Submission for Job: #6010 SSD 6010 - One Residential Building (Student Accommodation) within Darling Drive Plot

Site: #2824 SICEEP Site, The Haymarket; Darling Drive, Sydney

SSD 6010 - One Residential Building (Student Accommodation) within Darling Drive Plot

29 July 2013

Western Elevation (Existing Conditions)

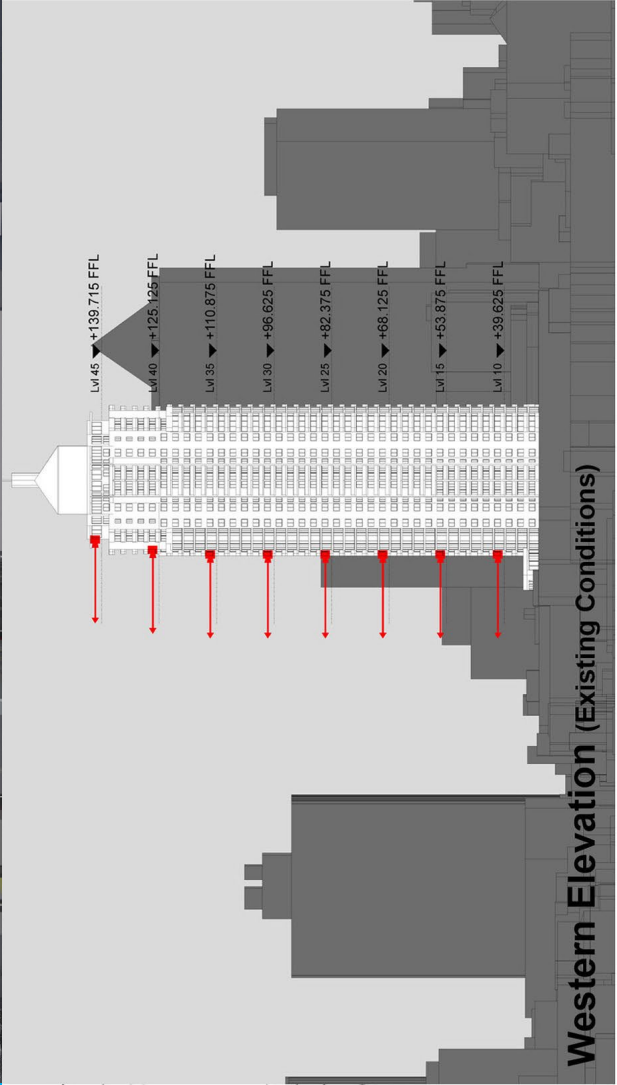
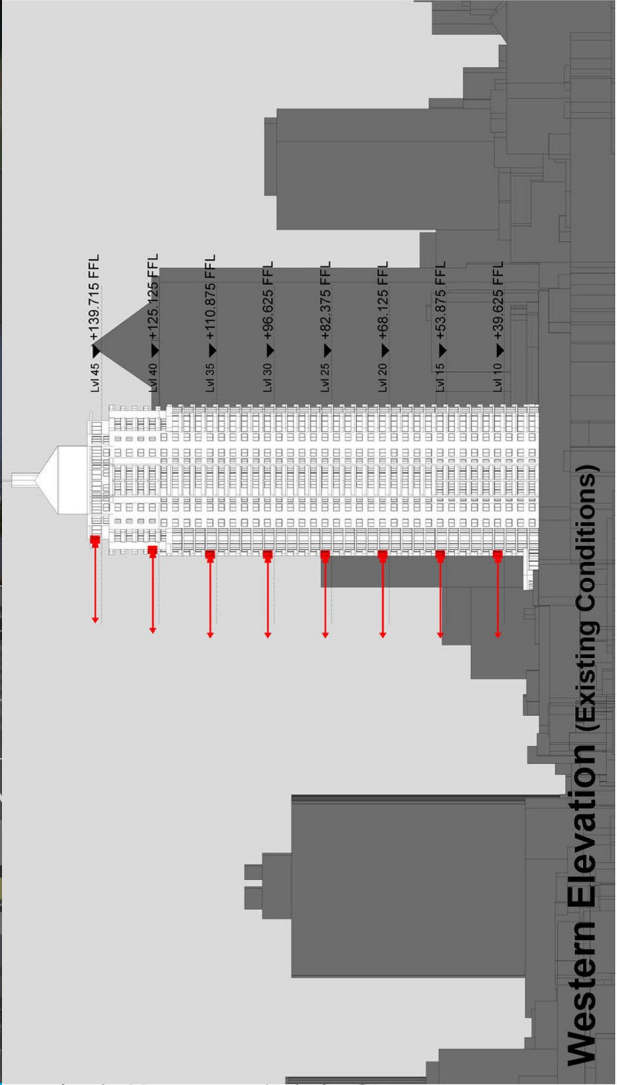
At 9am, 10am and 11am the west façade is totally in shadow due to other parts of The Peak building itself.

At 12pm there is still substantial existing shadowing on the west façade caused by the irregular shape of the west facade.

At 1pm the existing shadowing has been substantially removed, but not totally removed.

It can be concluded that some single aspect apartments on the west façade and some south-west dual aspect corner apartments currently receive less than 2 hours direct sunlight to habitable rooms and 50% of the private open space between 9am and 3pm on 21 June.

At 1pm the existing shadowing has been substantially, although not entirely, removed. However, overshadowing of lower levels of the west façade by the concept proposal parameter plan shadows for the N,NE and SE plots has already started.

By 2pm the existing shadowing has been totally removed. However, overshadowing of the west façade by the SSDA4 and SSDA5 buildings has appeared and risen further up the west façade than the concept proposal parameter plan shadows for the N,NE and SE plots, which is still present.

At 3pm, the proponent states correctly that 45-45% of the western façade is overshadowed by the SSDA4 and SSDA5 buildings.

It can be concluded that, as a result of combination of the proposed development with existing shadowing of the west façade, some single aspect apartments on the west façade and the south-west dual aspect corner apartments which currently receive less than 2 hours direct sunlight to habitable rooms and 50% of the private open space between 9am and 3pm on 21 June will suffer additional overshadowing. It is beyond our skills to count the number of such apartments. We note that the proponent has made no attempt to do so.
